Subject: **Review of Plans and Reponses to April 12, 2022 Review by  
Kolke Consulting Group**  
Proposed Koneru Residence  
6610 East Mercer Way  
Mercer Island, Washington

This letter is intended to respond to the geotechnical-related comments in the April 12, 2022 review letter from Kolke Consulting Group. For our review, we were provided with the civil drawings (PACE; May 11, 2022), architectural plans (McCullough Architects; June 12, 2022), and structural drawings (Malsam Tsang; May 5, 2022).

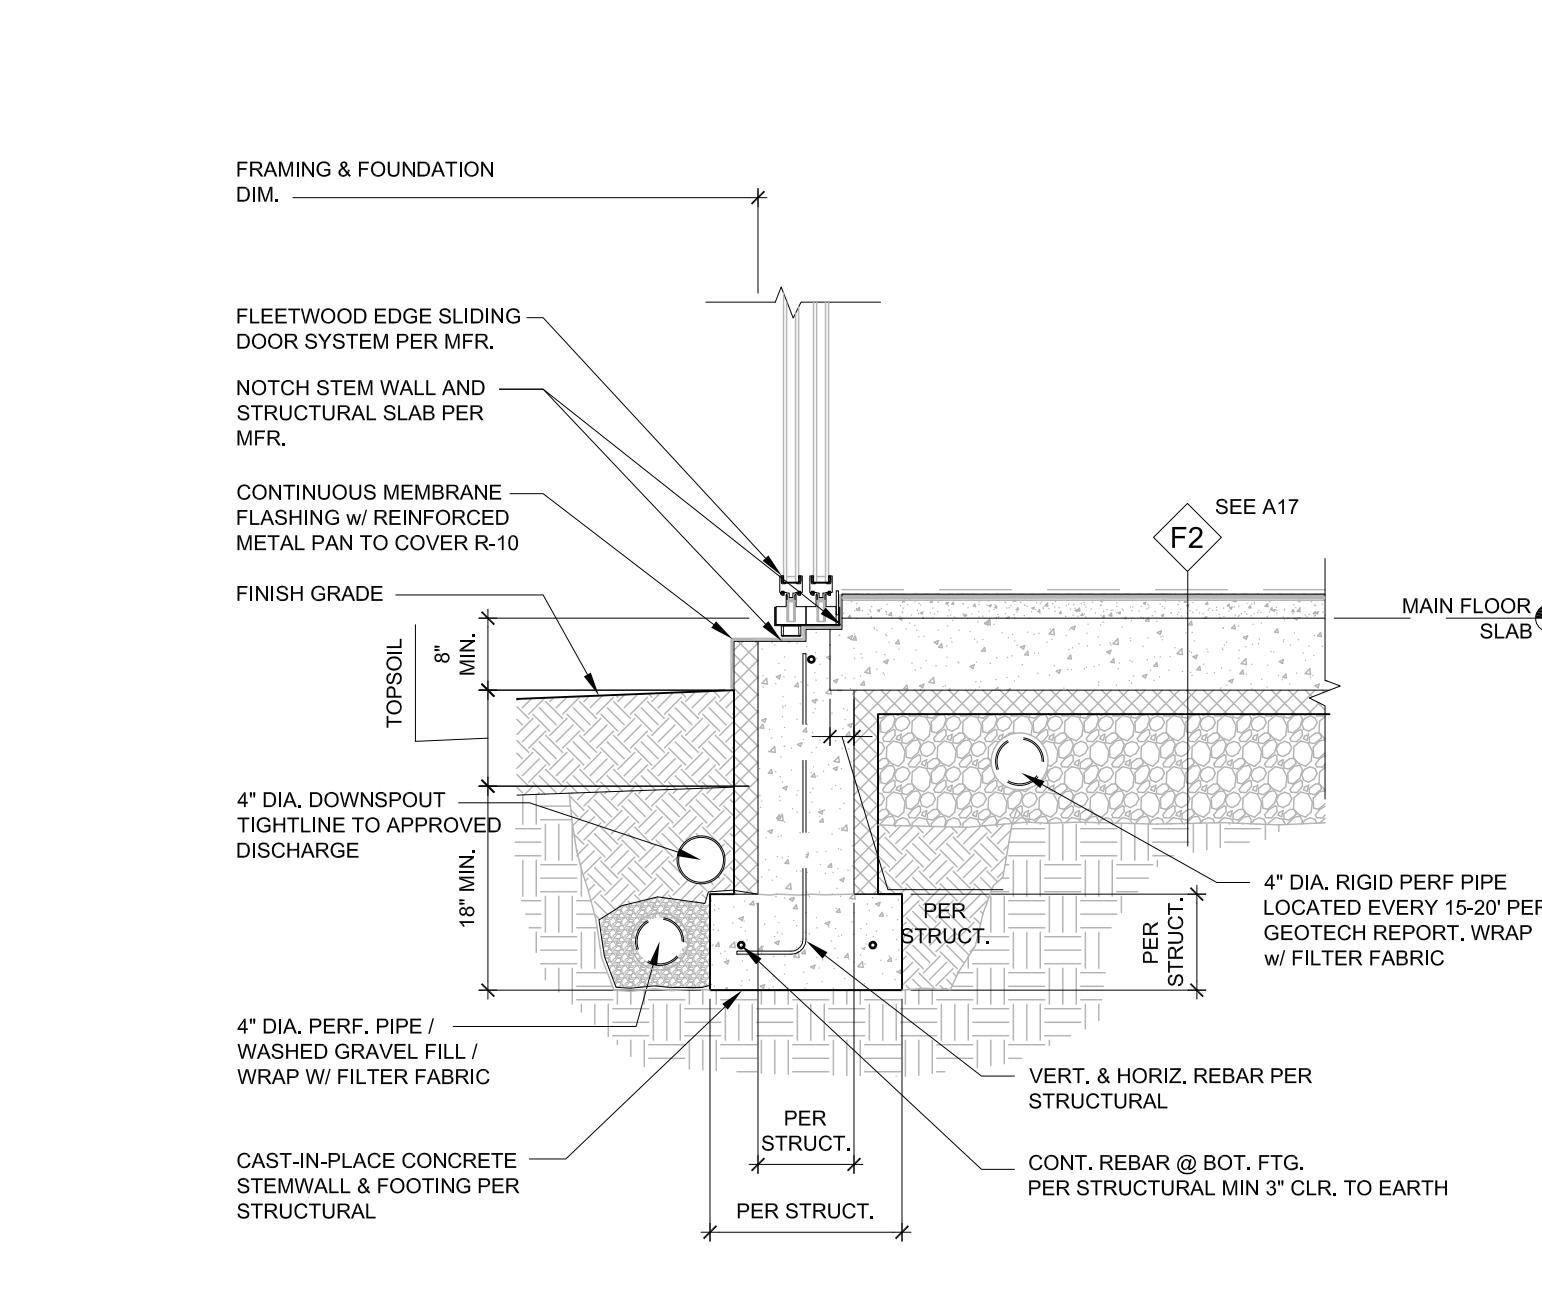
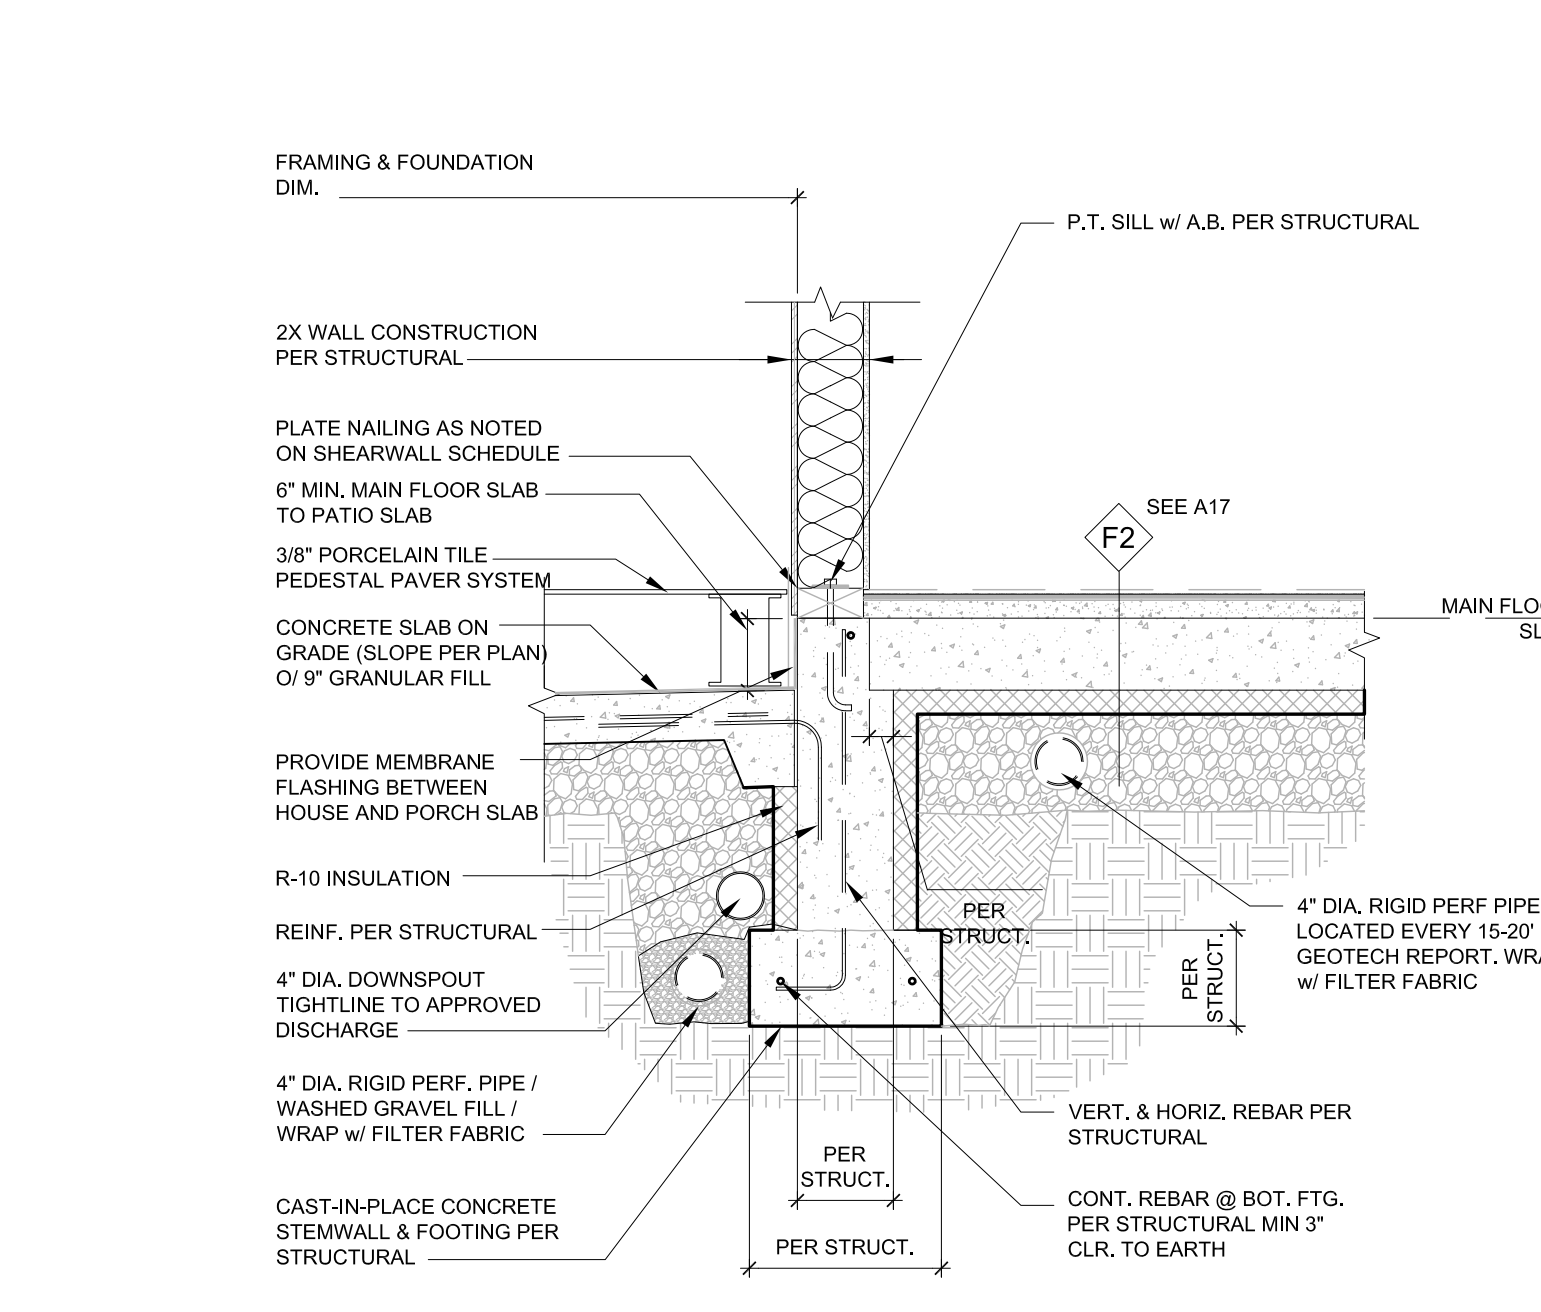
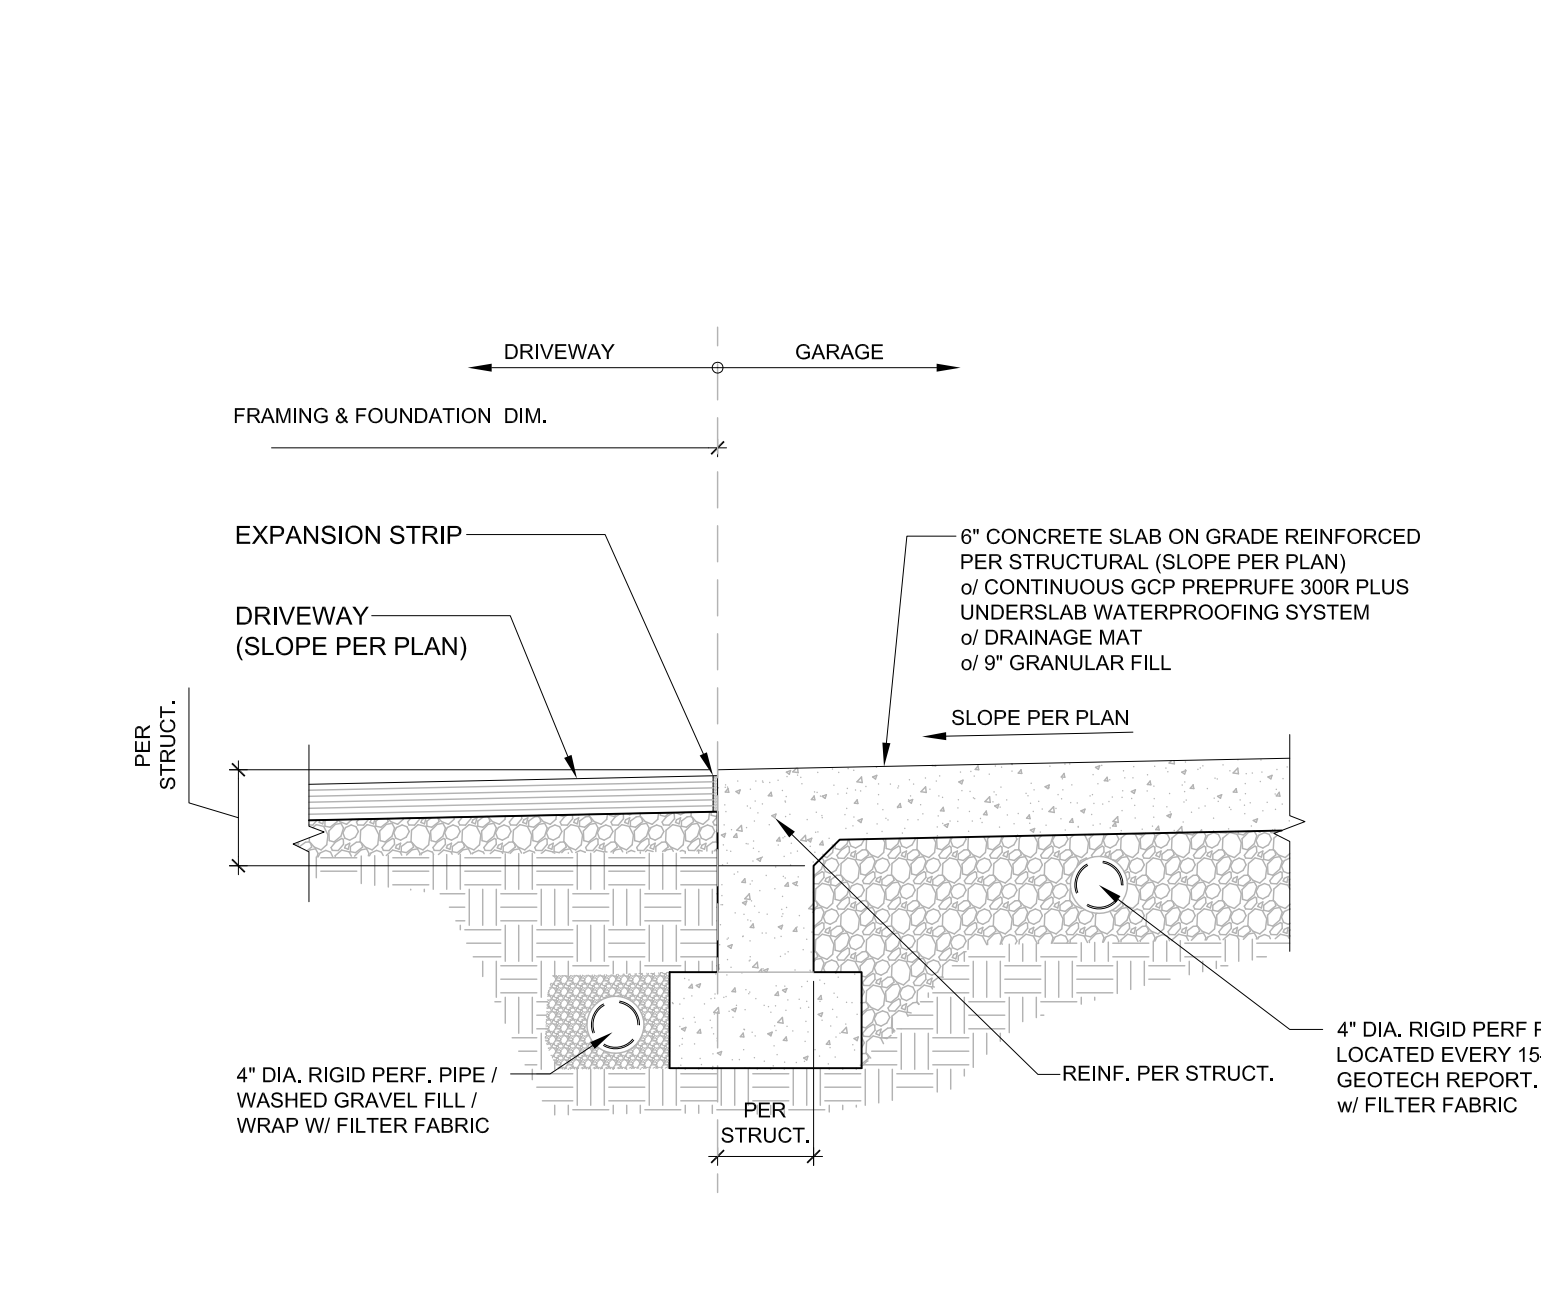
- 1) The slabs for the front porch and service patio are shown as 4-inch slabs-on-grade. It is important to note that these slabs will likely settle noticeably relative to the pile-supported residence. While this is not a structural issue, it may result in undesirable settlement and cracking over time. Changing these to pile-supported structural slabs would avoid this.
- 2) The swimming pool itself is indicated to be a deferred submittal item. It would be appropriate to include a pressure relief valve in the bottom of the pool, just as added protection against excessive hydrostatic pressure on the outside of the pool when it is drained for maintenance.
